Date: 20th August 2026
Ref.: JN 24219

Re: Response to Submissions in Relation to a Planning Application for a Strategic Infrastructure Development Comprising a 680 MW Gas-Fired Generation Station at Kilshane Road, Kilshane, Finglas, Dublin 11 (ACP-324305-26)

This current third-party submission response is submitted in reply to correspondence received from the Commission dated the 10th August 2026.

Client: Kilshane Energy Ltd.	Dwg No. 01
Drawing Title: Landscape Masterplan	Scale 1,500
Job No. 1961	Date 12/06/2025

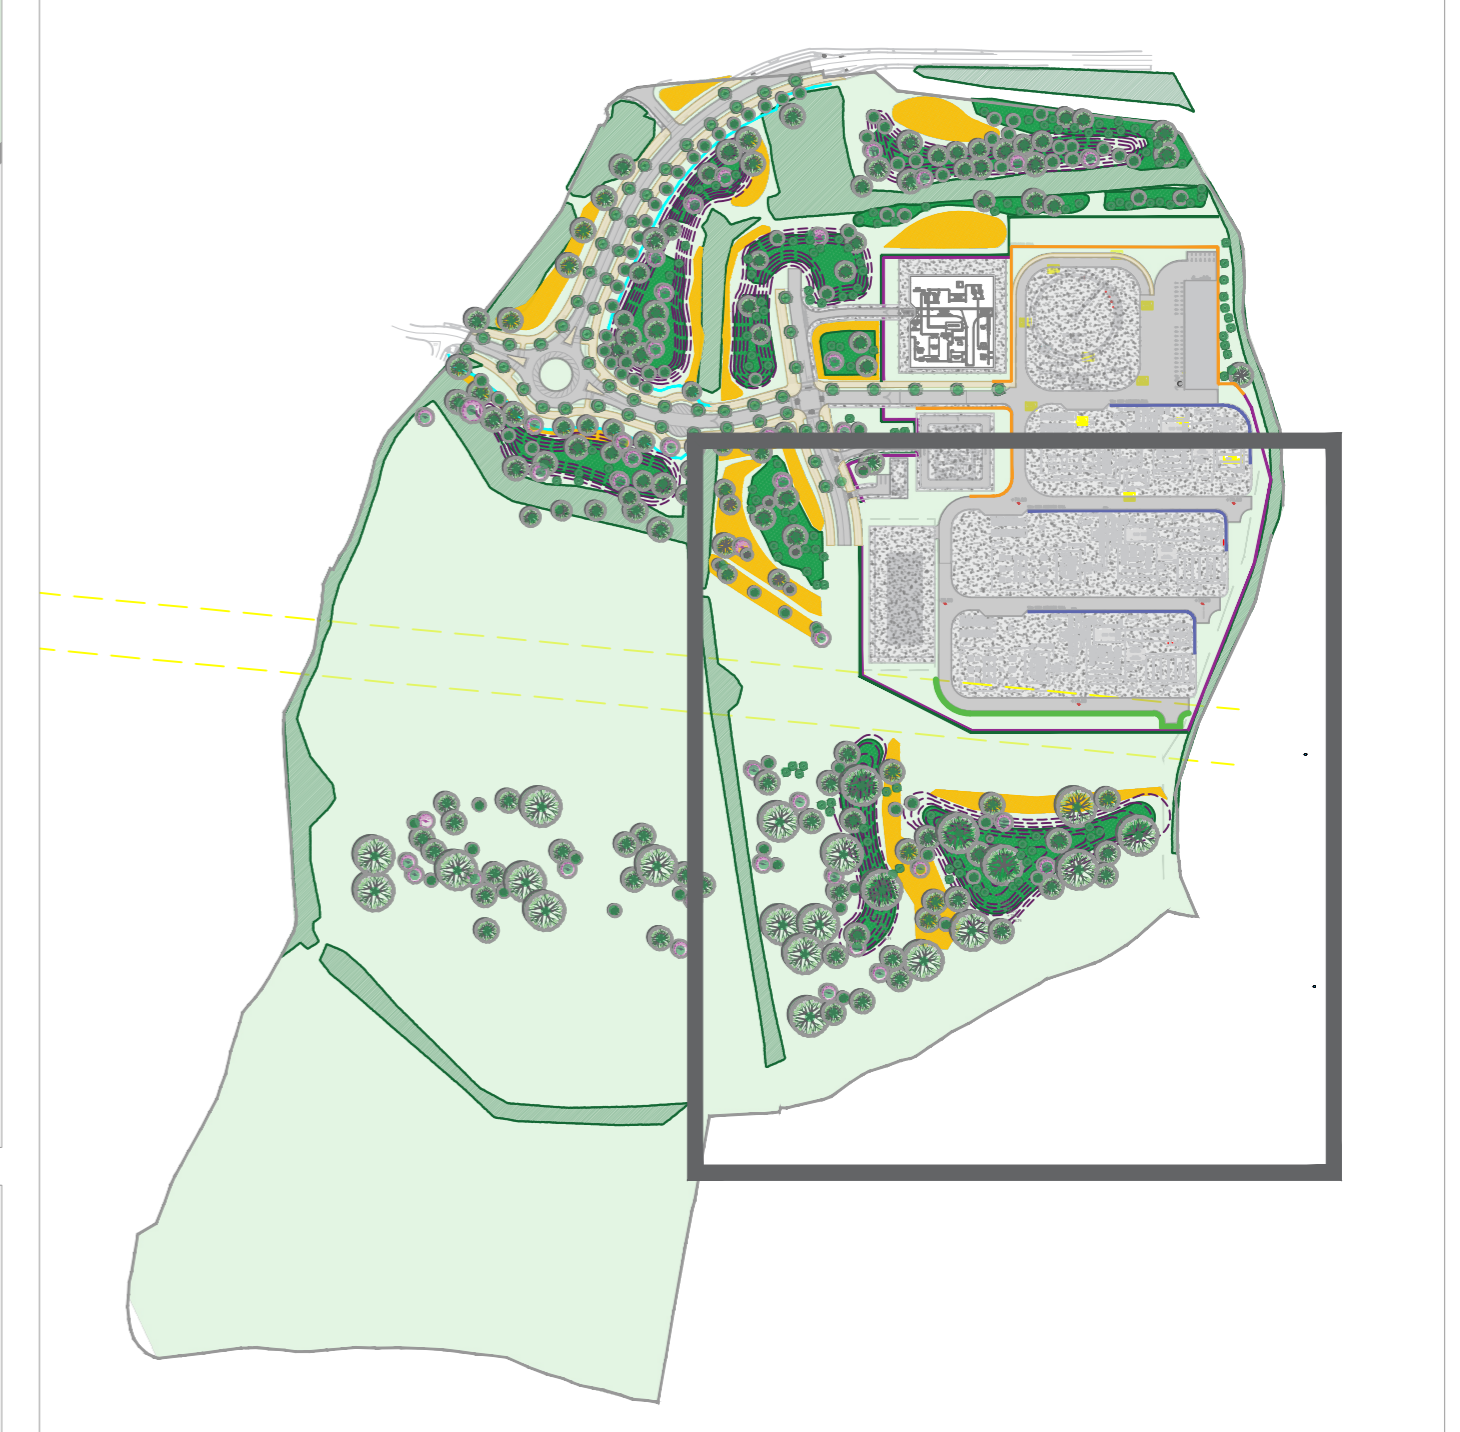
The remainder of the submission in respect of Nature Conservation focuses on the inclusion of wildflower meadow within the landscaping scheme for the development, and raises several points with regard to the use of seeds of non-local origin.

A condition is suggested to require that commercially sourced wildflower seeds be omitted from the landscaping scheme, in favour of *"germination of wildflowers from the existing site soil seed bank or natural dispersal and the maintenance of these meadows by implementing an appropriate future mowing regime"*.

This approach has been reviewed by the project landscape architects and the applicant, and it is confirmed that the applicant will commit to this approach instead of using commercially sourced wildflower seeds, in order to conserve the genetic diversity of locally occurring wildflower populations. A condition to this effect would be acceptable if required.
